Re: BusConnects Belfield/Blackrock to City Centre Core Bus Corridor Scheme
Co. Dublin

Reference: Bus Connects – Belfield Blackrock Scheme

Case reference: ABP-313509-22
Dublin City Council

Submission / observations:

Programme Title: <b>BUSCONNECTS DUBLIN CORE BUS CORRIDORS INFRASTRUCTURE WORKS</b>			
Drawing Title: BELFIELD / BLACKROCK TO CITY CENTRE CORE BUS CORRIDOR SCHEME GENERAL ARRANGEMENT			
Drawing File Name: BCIDC-ARP-GEO_GA-1415_XX_00-DR-CR-0021	Sheet Number: 21 of 24	Status: A	Rev: M01

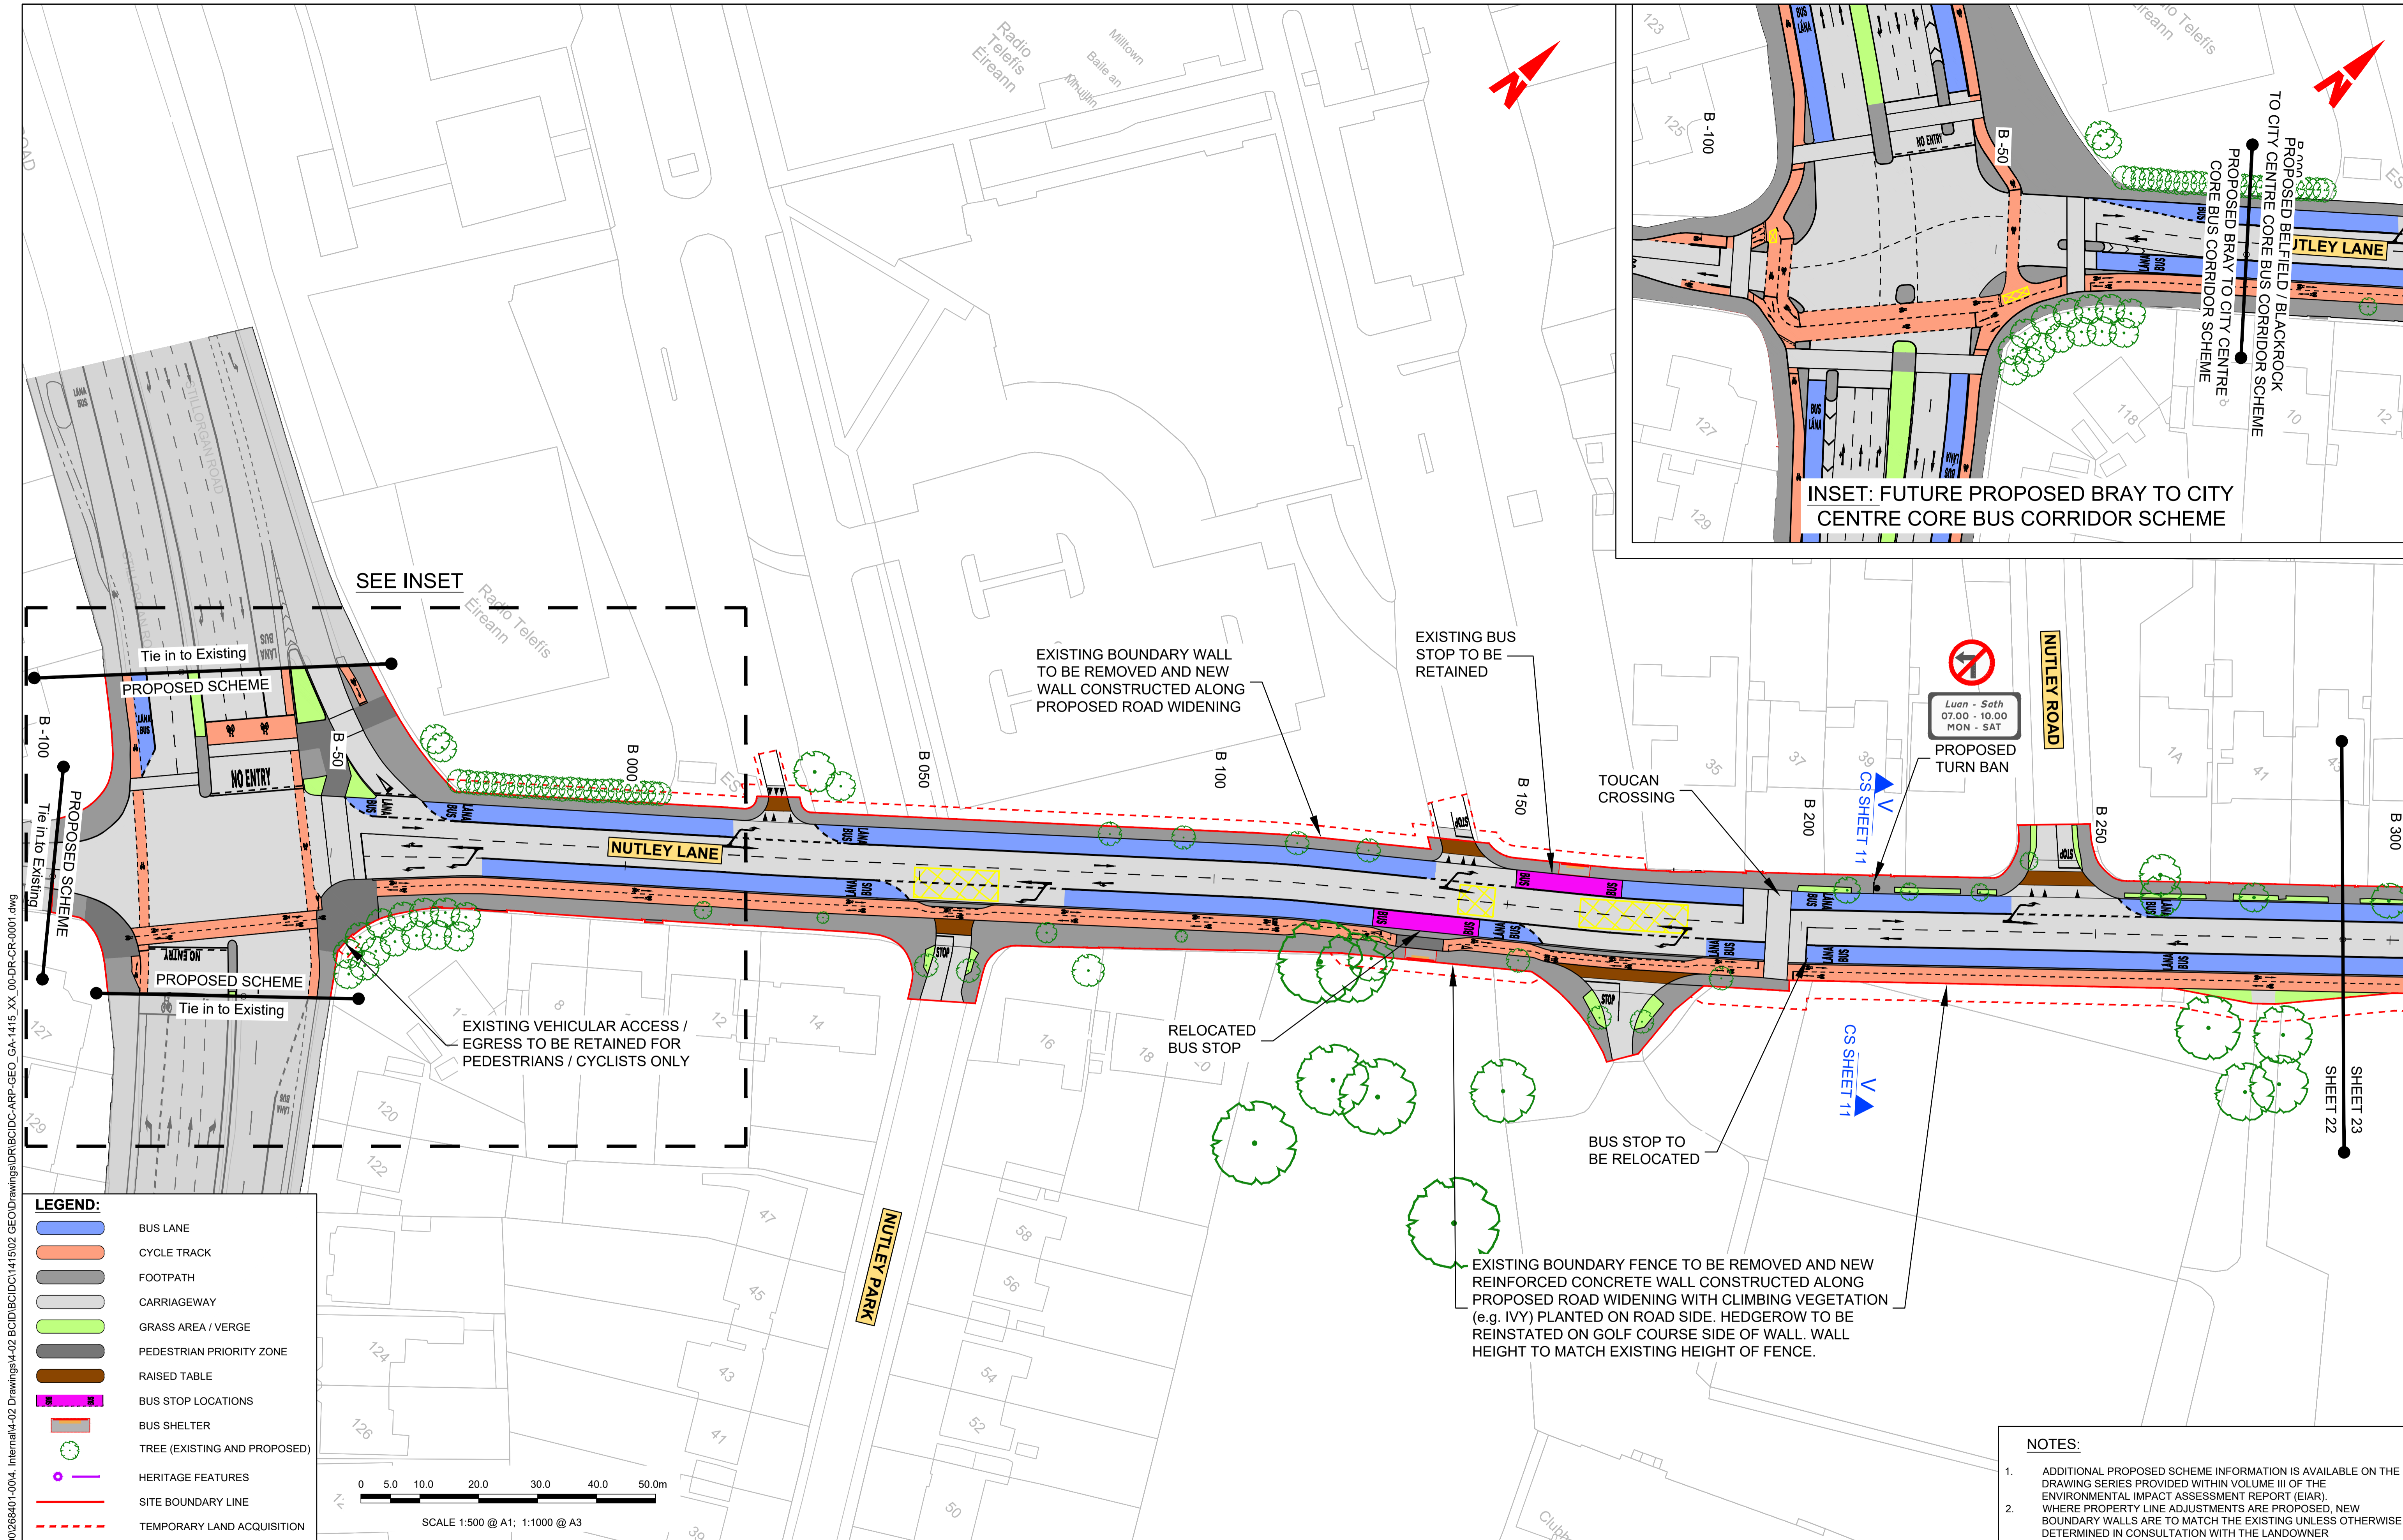
**1. Safety Concerns – Bus Stop re-location – Fitzwilliam Street Lower (Inbound)
– Blind Spot created**

The proposed new location for the new Bus Stop is at the junction of Fitzwilliam Street Lower & Fitzwilliam Lane.

It is replacing the current no parking/chevron area which was installed to protect cyclists & pedestrians when the existing cycle lane was opened.

Below photos mark the Proposed Bus Stop location which would replace the current chevron no parking area (plus car spaces). This will create an extremely dangerous blind spot for traffic turning into Fitzwilliam Lane from car traffic in both directions when busses are stopped. Motorists will be unable to see both cyclists and pedestrians.

In addition the new location on Fitzwilliam Street Lower creates a greater distance from the nearest pedestrian crossing – which is counter to the reports own recommendation of having bus stops located as near as possible to pedestrian crossings for the safety of commuters.

In summary, the moving of the inbound bus stop from Baggot Street Lower to Fitzwilliam Street Lower creates many safety issues with no benefits, therefore should not proceed.

Current Inbound Bus Stop - Lower Baggot Street footpath width: 330cm

Proposed relocated Inbound Bus Stop – Fitzwilliam Street Lower footpath width: 215cm.

This is over 1 metre narrower and one of narrowest footpaths in the area. The street itself is too narrow to widen footpaths and allow for all the planned traffic lanes.

Fitzwilliam Street Lower is less suitable than the current location of Lower Baggot Street for commuters to wait for buses as it will obstruct pedestrians.

Two shared landing bus stops are now proposed in the plan:
